OBJECTION

SSD APPLICATION NUMBER SSD17_8669

Our comments are in relation to the **Junior School site** with particular reference to the corner of Humphreys Lane/Bligh Street.

Phase Three: Junior School

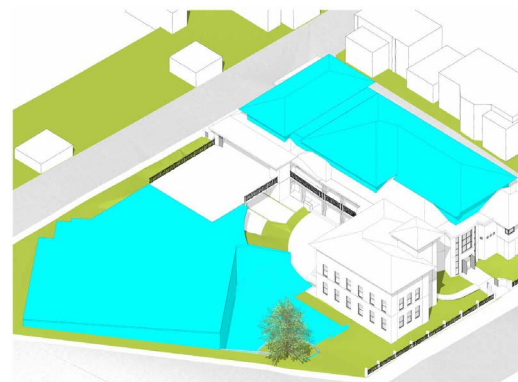
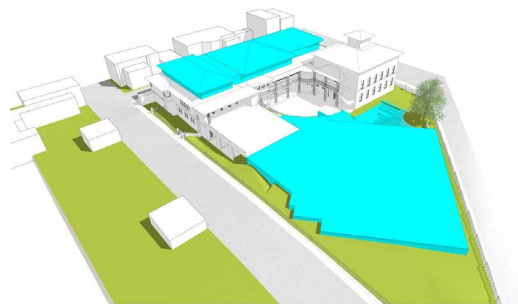
We object to the second storey proposed for this development as it will cause overshadowing of our back garden and living areas for most of the day, as these areas face due north.

We object to the Junior School Concept Plan as the increase in height with the additional storey will hugely impact our privacy. The extra level's windows will look directly into our bedroom, living room (where we spend most of the day during school hours), and swimming pool. In addition, I believe the current building height is at its maximum level allowed by EPA and state zoning. Adding an extra level would be in breach of these restrictions.

We object to approval of the Concept Plan for the Junior School as the EIS does not contain sufficient detail to allow appropriate comment . We have not been provided with height planes or detailed shadow diagrams to accurately assess our solar loss or privacy loss.
